From: John Peverada
To: David Margolis-Pineo; Errico Thomas; Jean Fraser
CC: Jeremiah Bartlett; Philip DiPierro
Date: 4/11/2014 2:21 PM
Subject: Fwd: RE: 118 on Munjoy Hill - Revised Construction Management Plan

From: Jean Fraser [mailto:JF@portlandmaine.gov]
Sent: Wednesday, April 09, 2014 2:59 PM
To: Bourke, Jeanie; Machado, Ann; Stanley, Virginie
Cc: Bergeron, Rick; Carey, Tom; Greer, Tom; Lloyd, David; Newell, Chip; Pitman, Cordelia
Subject: Re: 118 on Munjoy Hill - Revised Construction Management Plan

On January 28th, 2014 the Portland Planning Board requested nine (9) conditions of approval of a Level III Final Site Plan and Subdivision proposal for "118 on Munjoy Hill" Condominium 12 unit residential, and 2 unit commercial, condominium #2013-255 located at 118 Congress Street . CBL:16-D-2

Drawing file: Superceded plans / superceded Construction Management Plan.pdf

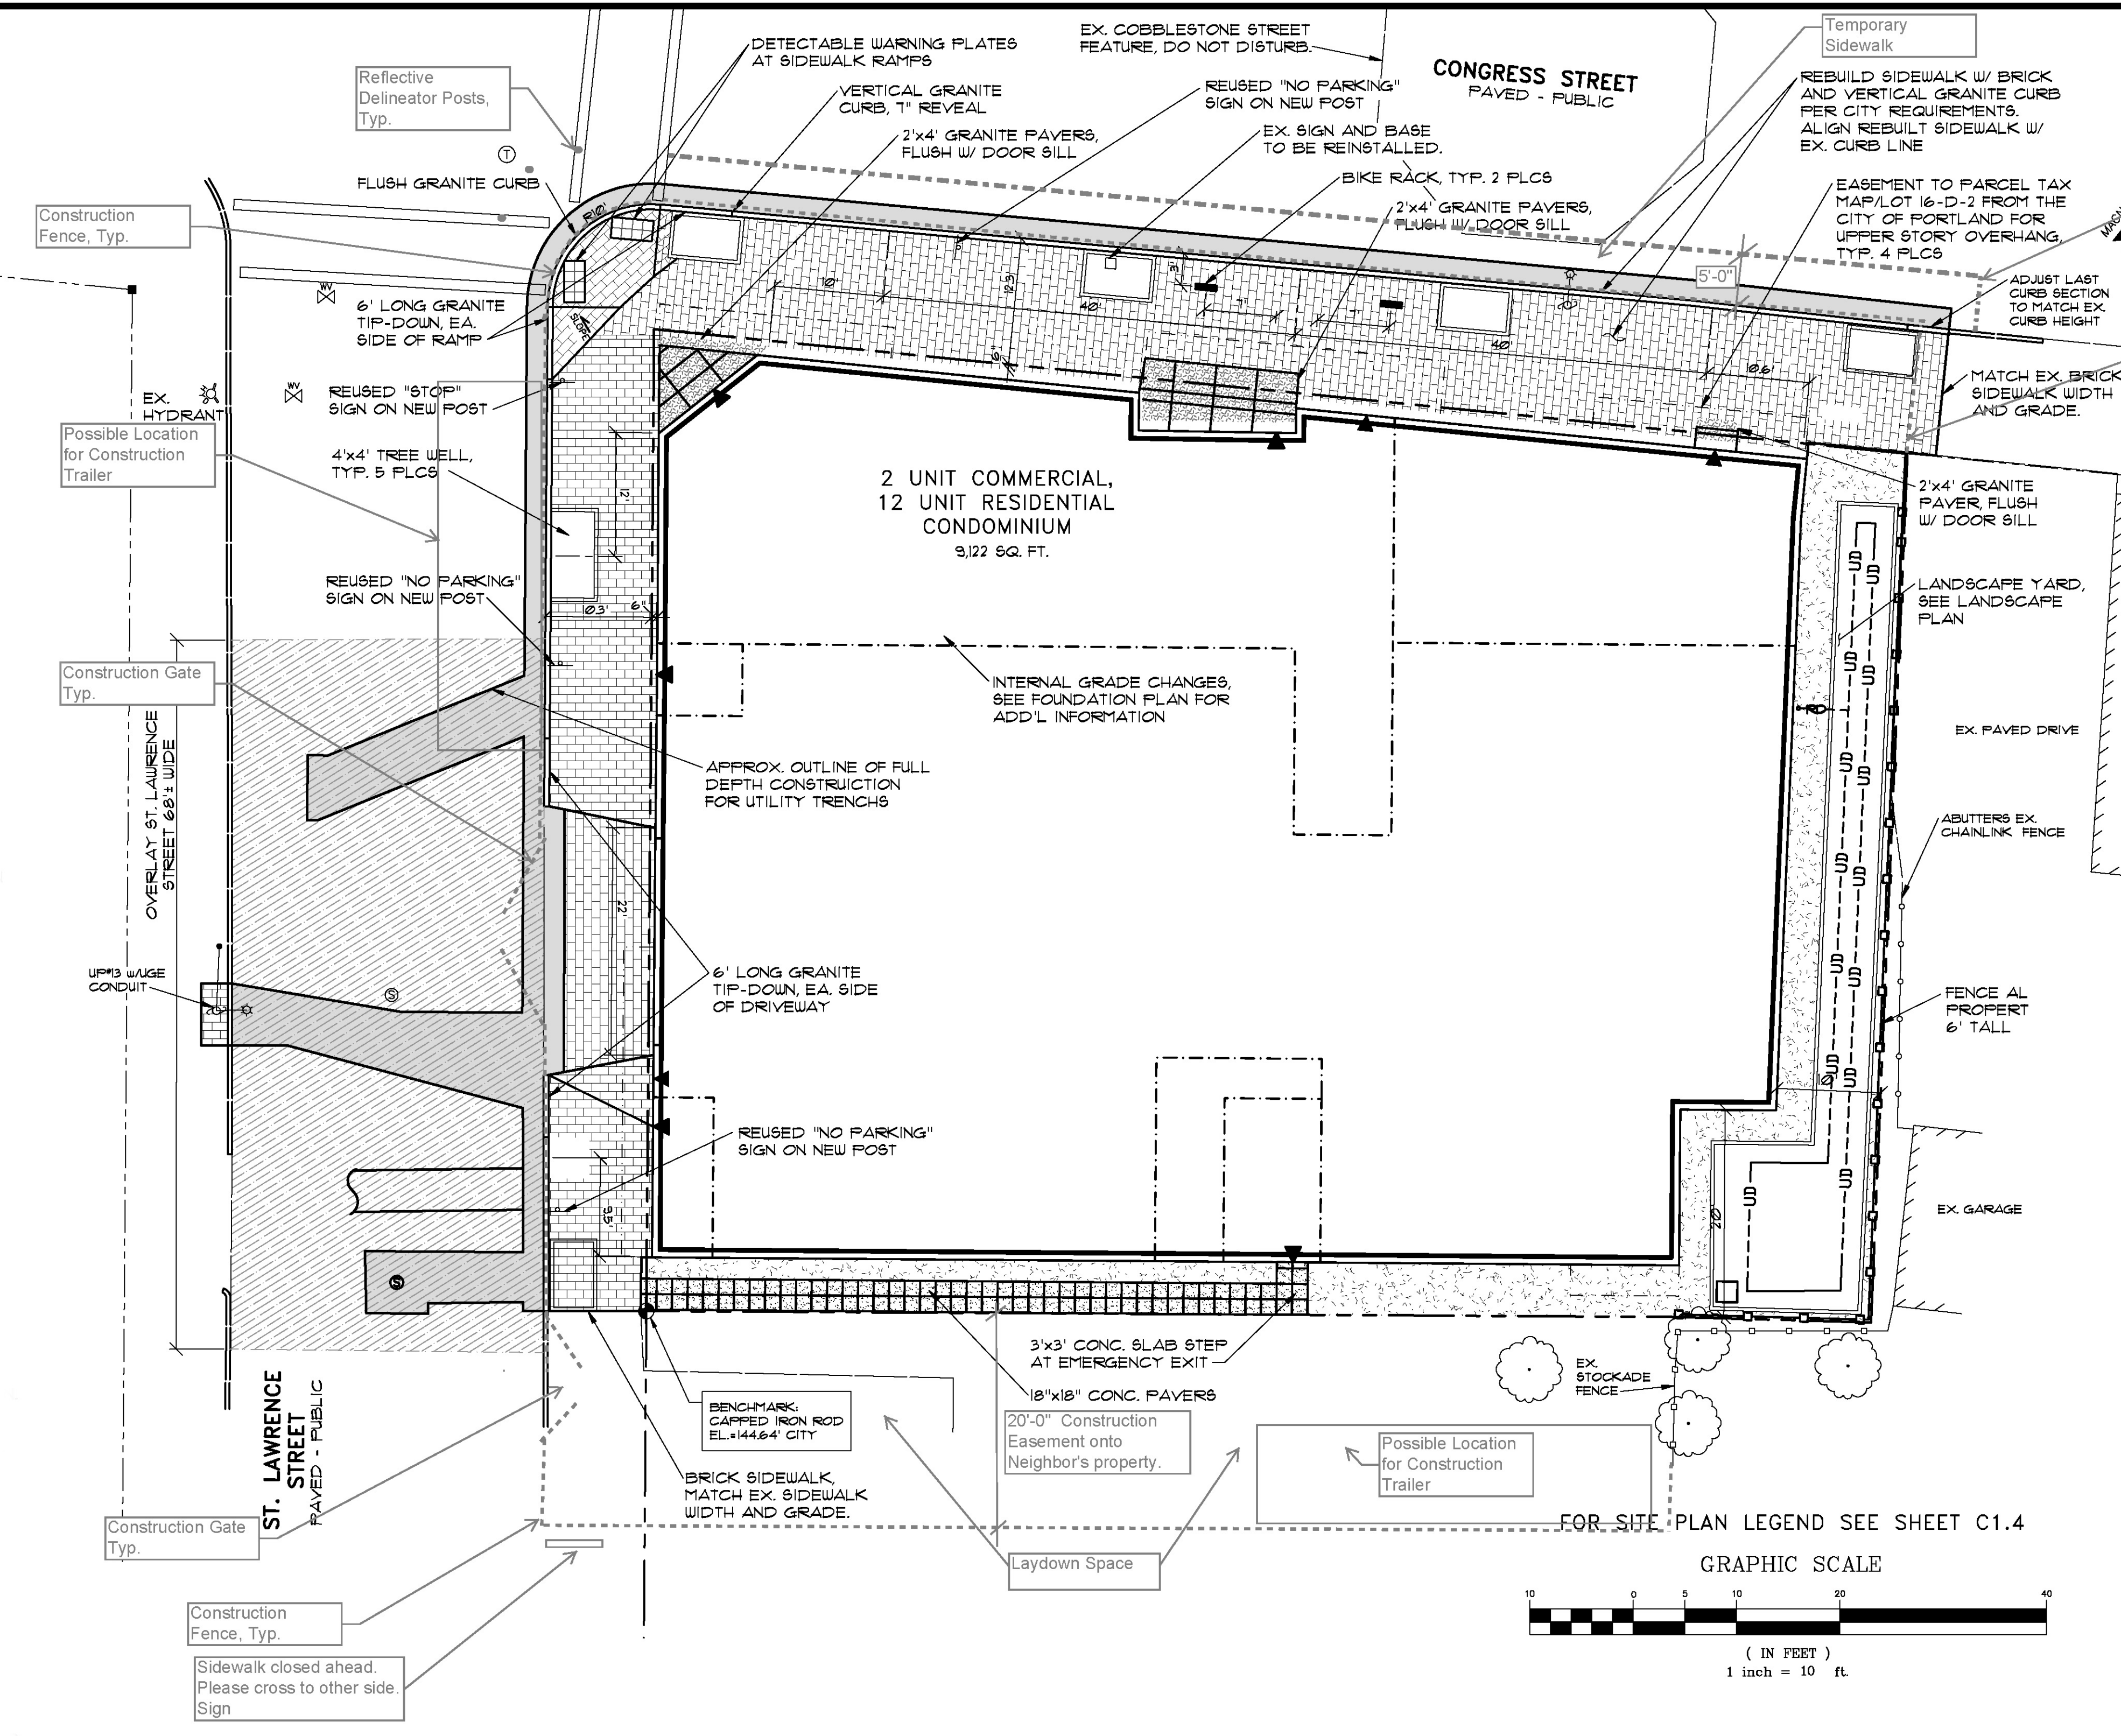
DPS have the following comments on the CMP letter and plan submitted April 1, 2014 - please note that Tom Errico, Traffic Engineering reviewer, Captain Chris Pirone of the Fire Department, and John Peverada, Parking Manager, all concur with these comments:
We would like the applicant to eliminate the proposed mid-block "temporary crosswalk" on St. Lawrence

St and post a "Sidewalk Closed Ahead - Cross Here" sign at the intersection of Monument and St Lawrence; The proposed temporary sidewalk layout (Congress Street) is acceptable to Public Services but will occupy approximately four parking spots on Congress Street. One is a U-Haul Car Share spot. At least one week before the temporary sidewalk is installed, the developer will need to work with John Peverada to relocate the Car Share location. Since four parking locations will be occupied, there will be a \$15/day or \$420 fee per week for occupying these parking spots.

Please revise the plan as requested - also it would be easier if the notes in the letter were added to the plan where not already identified, so all the information is on one plan. Please send the final version of the CMP to me so I can get a final "sign off" and confirm to you that the condition has been met.

Attached please find a revised Construction Management Plan dated 4/10/14. Wright Ryan Construction incorporated the changes requested in your email below.
